CROSSROADS MIXED USE FILING NO. 2

CONSTRUCTION PLANS

EL PASO COUNTY FILE NO. SF2238

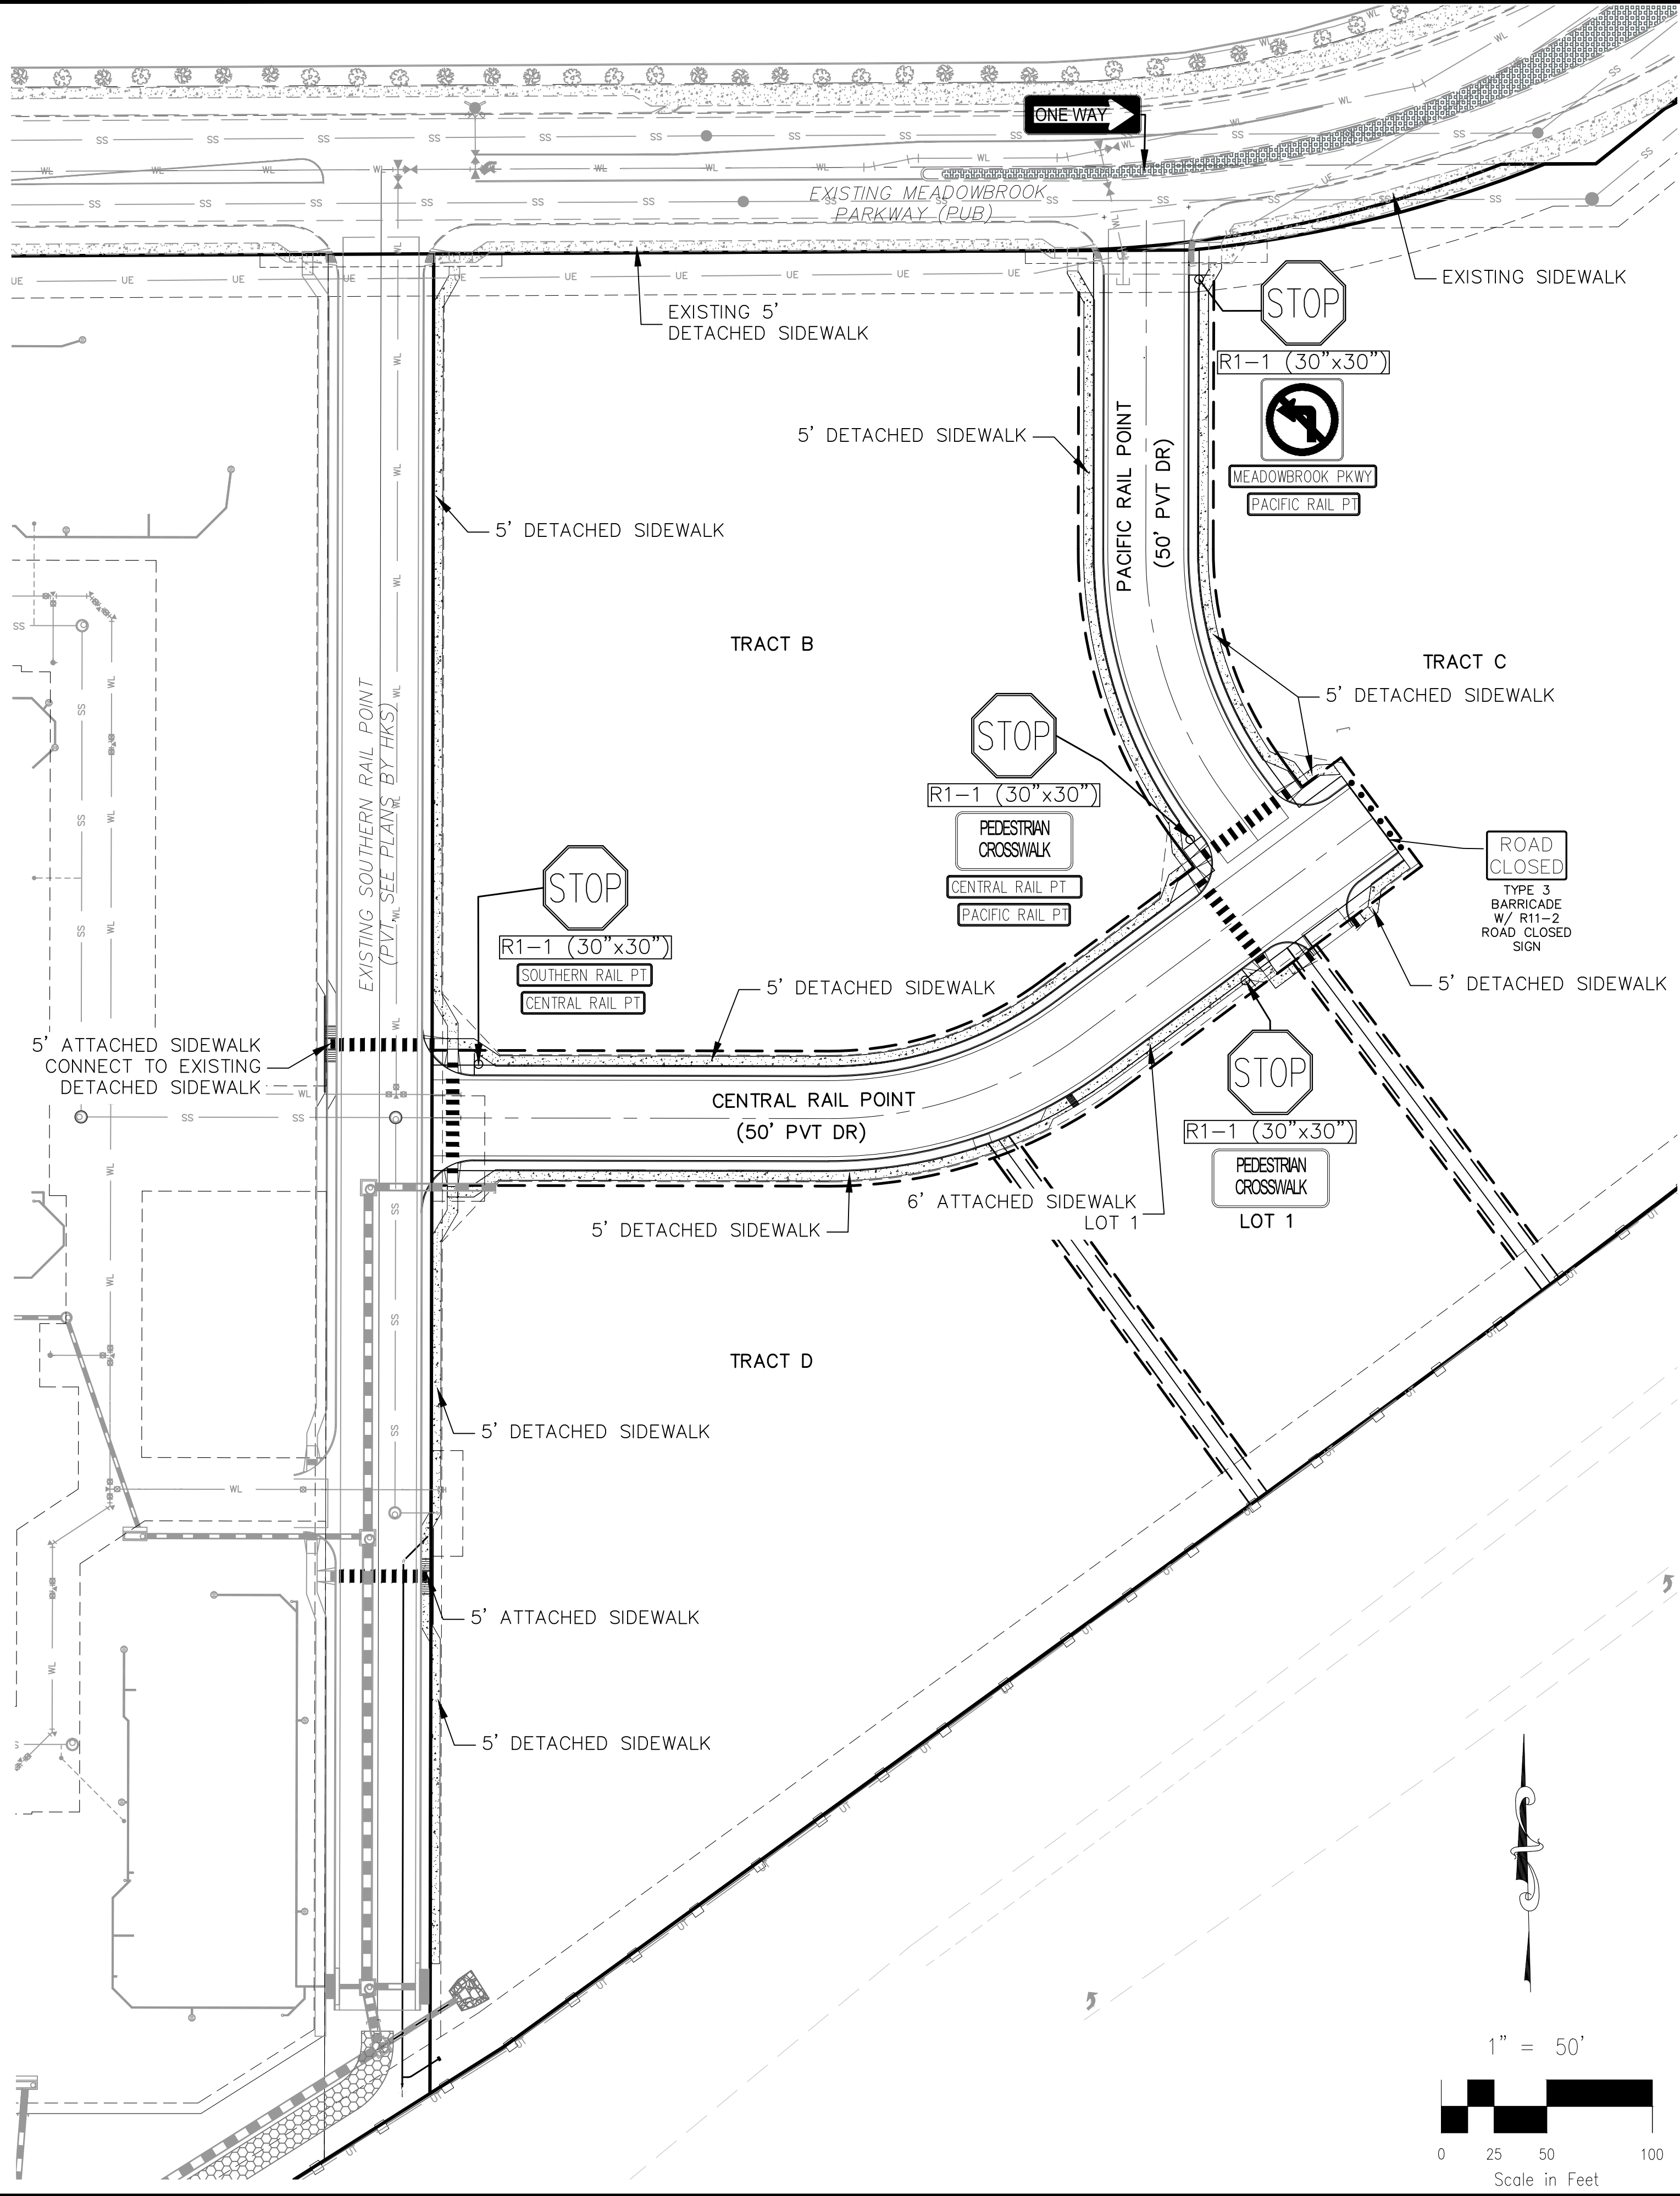
Unresolved from review 1 and 2. Update cross section to provide sidewalk on both sides per the approved deviation request filed under PCD File No SP2011.

Deviation was denied. Please update to include sidewalk on appropriate places.

- Unresolved from review 1 and 2. update all proposed sidewalk alignment at the intersections per the county standard detail.
- Unresolved from review 1 and 2. Show/Install sidewalk along the east side of Southern Rail Point.
- The drawings have been updated to include a sidewalk all along the east side of Southern Rail Point.
- Deviation was denied. Please update to include sidewalk on appropriate places.
- Drawings have been updated to include the sidewalks on each side as in appropriate places with ramps.
- Unresolved from review 1 and 2. Per Aura at Crossroads see snippet. Revise to provide a sidewalk/crosswalk across proposed curb ramp per ECM 2.5.2.C.3 and 2.5.2.C.4.
- Sidewalks have been added to provide a crosswalk and ramp across the proposed curb. However, the located mentioned to connect to Aura at Crossroads is further south.

Drawings have been updated to include the sidewalks on each side as in appropriate places with ramps.
